**Manning Colliery Modification 2 (MP06_0311)
Chain Valley Colliery Modification 1 (SSD-5465)**

NSW Trade & Investment, Regional Infrastructure & Services, Division of Resources & Energy (DRE) has reviewed the *Manning Colliery – Modification 2 Environmental Assessment Section 75W Modification to MP06_0311 (EA)* and the *Chain Valley Colliery – Modification Statement of Environmental Effects Section 96 Modification to SSD-5465 (SEE)* dated April 2014 and provides the following comments which are directed at specific areas of DRE responsibility for this proposal.

**Figure 2:** Proposed underground linkage between Chain Valley and Mannering collieries

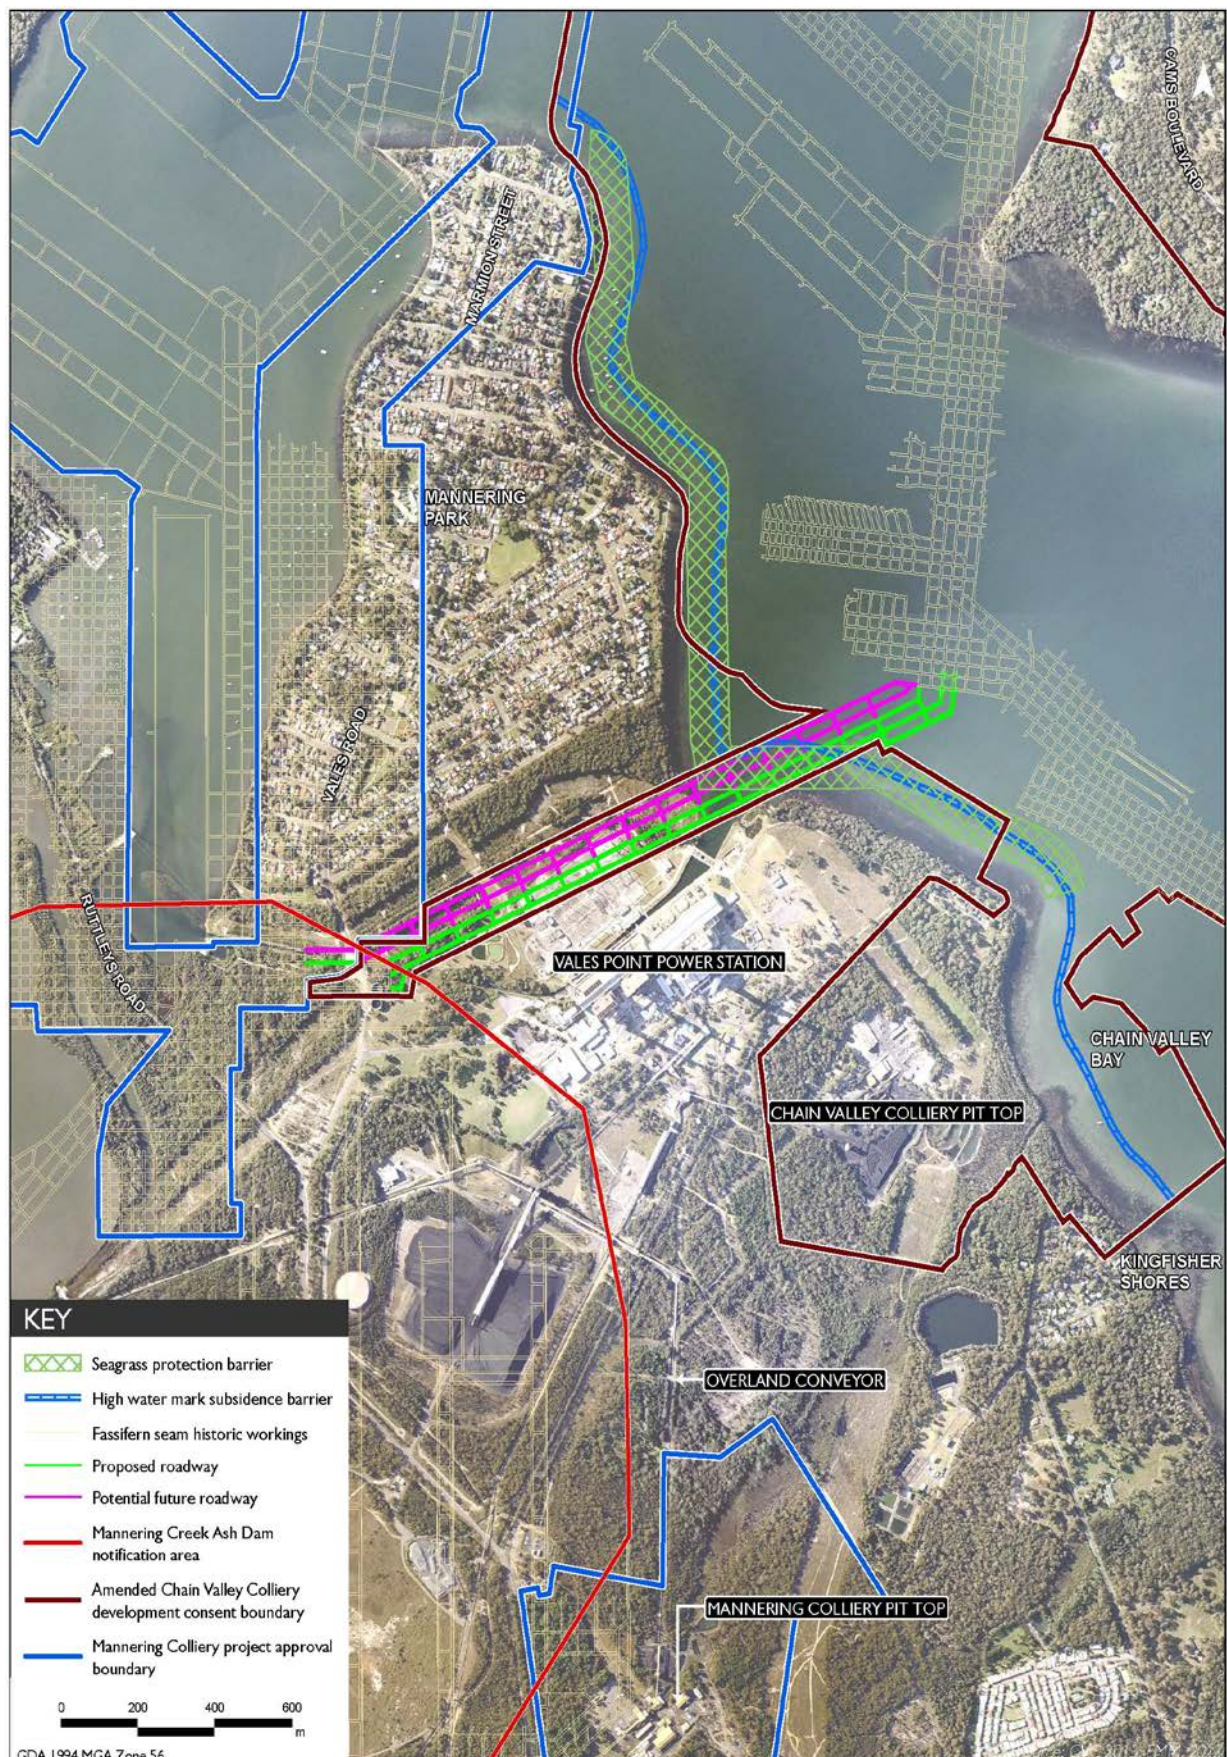
In regard to subsidence, DRE notes that both the EA and the SEE state that "Maximum vertical subsidence from the roadway development will not exceed 20 mm" (Section 3.2.1 5.2 and Appendix C in the EA and SEE). However the site is characterised by the presence of:

- critical electrical transmission infrastructure that may potentially be highly sensitive to mine subsidence
- multi-seam workings that may interact with the proposed workings, which may contribute to the development of mine subsidence, and
- complex geotechnical conditions.

In view of the significance of the surface features and complex site conditions, DRE suggest that the proposed mining be independently reviewed by an expert(s) based on site specific conditions. The said expert(s) should have demonstrated expertise relevant to the proposal and site conditions.

The proposed mining be independently reviewed by an expert(s) based on site specific conditions. The said expert(s) should have demonstrated expertise relevant to the proposal and site conditions.
